Planning application reference: 6/2015/1998/LB

Site: Comet Hotel, St Albans Road West, Hatfield, AL10 9RH

Proposal: Extension and refurbishment of the Grade II listed hotel following demolition of existing extensions. Erection of student accommodation comprising of 361 beds, landscaping and associated works

Thank you for consulting the Twentieth Century Society on the above application. The Society considers The Comet in Hatfield to be one of the most important and significant of the 'Moderne' style pubs from the interwar era. Grade II listed, it was designed by E.B. Musman in 1936. Musman was a pioneer of radical pub design, and also responsible for the Nags Head at Bishops Stortford. These two pubs stand out as of particular interest, in an era where pub design was more likely to be of the 'Tudorbethan' roadhouse style favoured in the expanding suburbs. Revolutionary pubs are now extremely rare and all endeavours should be focussed on their preservation and survival for the enjoyment of future generations.

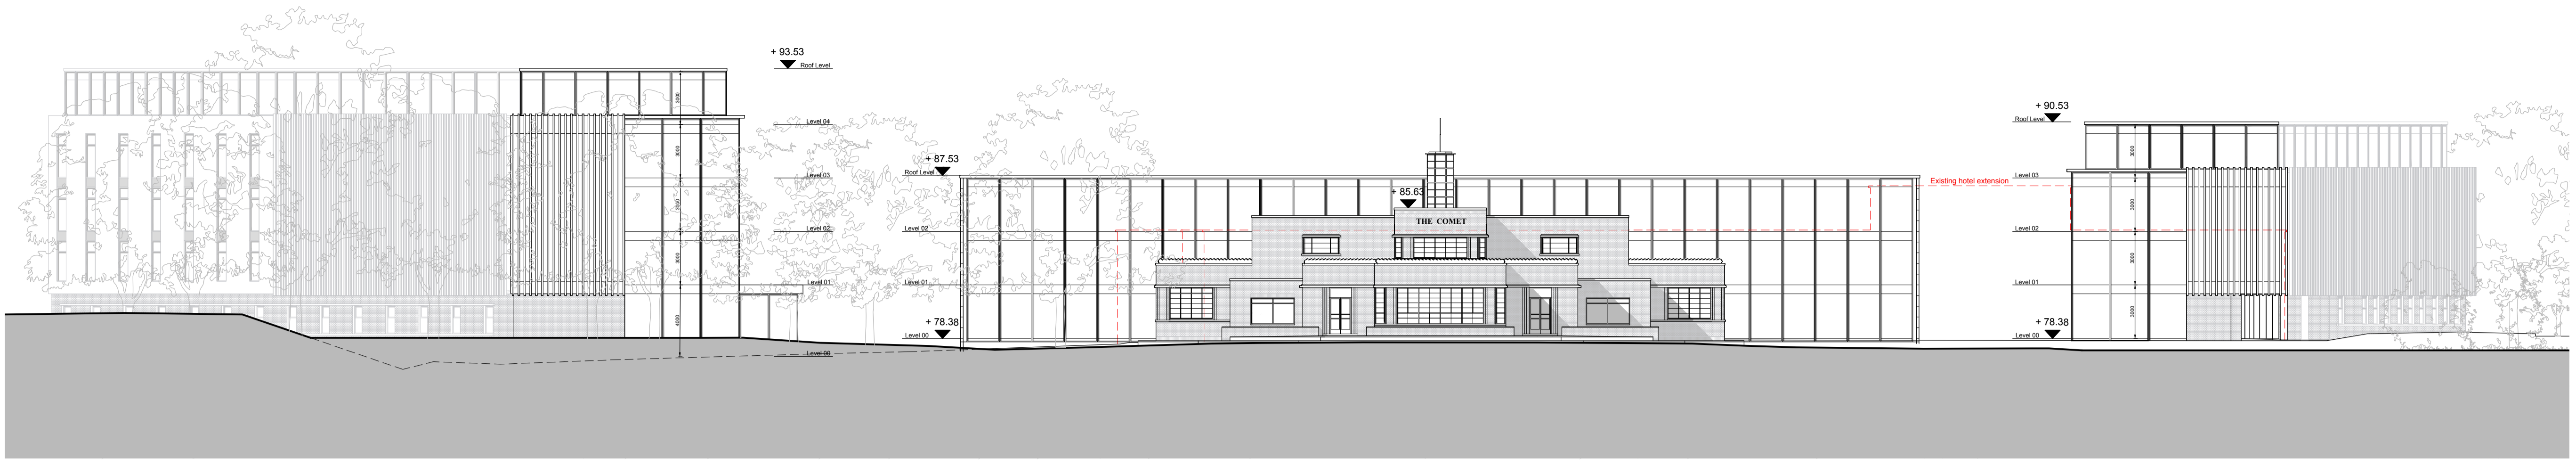
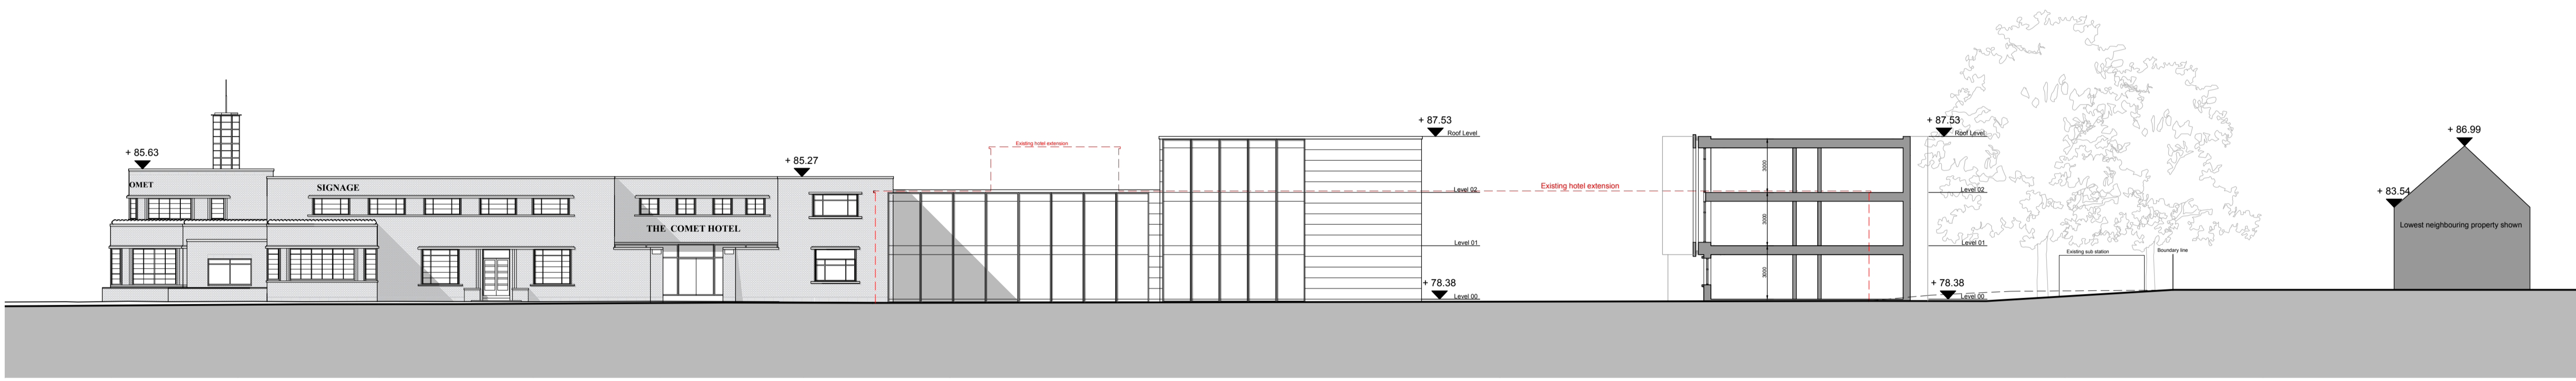
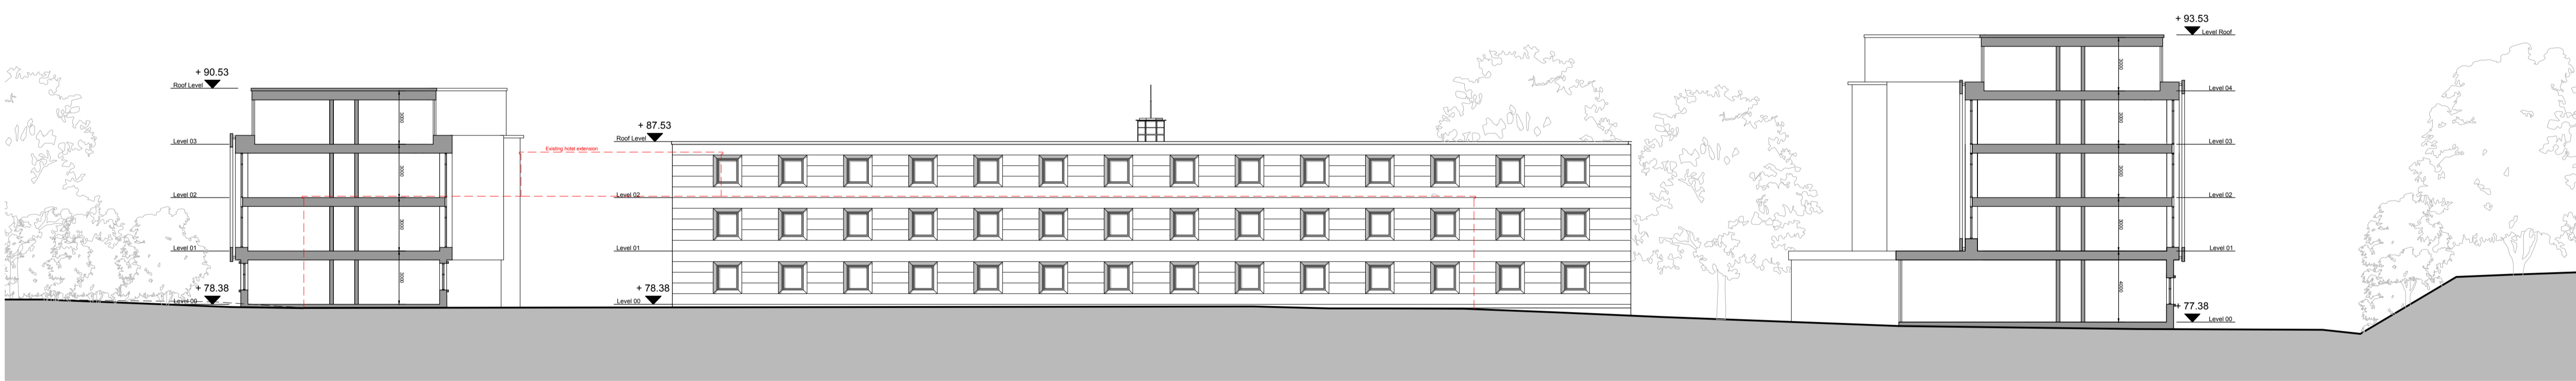
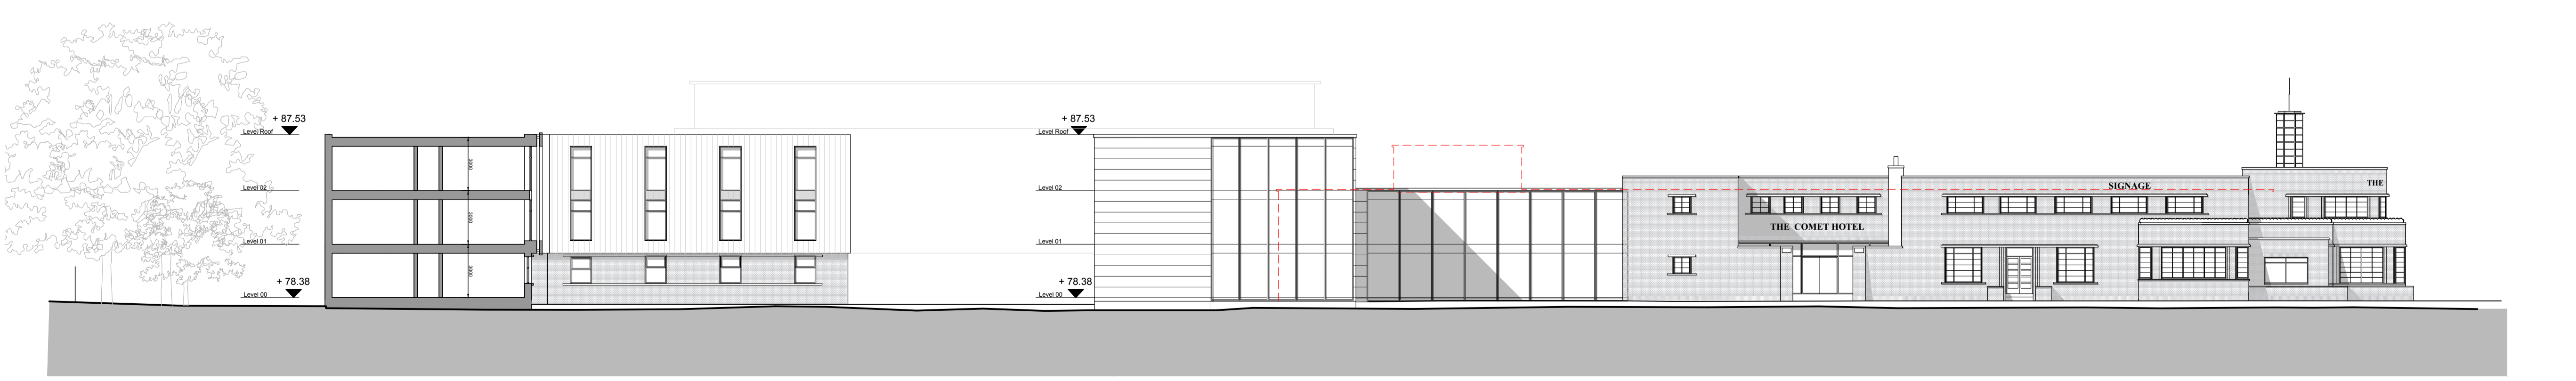
The Society acknowledges that care has been taken to replace the later extensions and additional buildings on site with more subservient designs that respect the setting of the listed building, however, we remain concerned over the height of the proposed replacement buildings: both the hotel extension to the listed building itself and the proposed student accommodation. The Society would prefer to see the original footprint of the listed building reinstated, but considering that the principle of extending the building is established, would comment that any extension should be of a similar or lower height to the listed building. The proposed 2 storey link block is of an appropriate height in this regard but the Society considers that the 3 storey rear extension has the potential to be overpowering. The Society understands that attempts have been made to minimise the height of this extension since the original proposals, but considers it regrettable that despite these efforts the extension remains above the height of the listed building.

Similarly the height of the student accommodation is of concern, particularly where it will be visible to the proposed hotel extension to the north-west of the site. Again the Society would prefer not to see this quantity of development within the setting of the listed building, but understands that the principle is established by previous construction. We would re-iterate that any development on this

part of the site should be subservient to the listed building and would therefore like to register our concern that the height of the proposed building will harm the setting of the listed building by drawing the eye and attention away from the heritage asset.
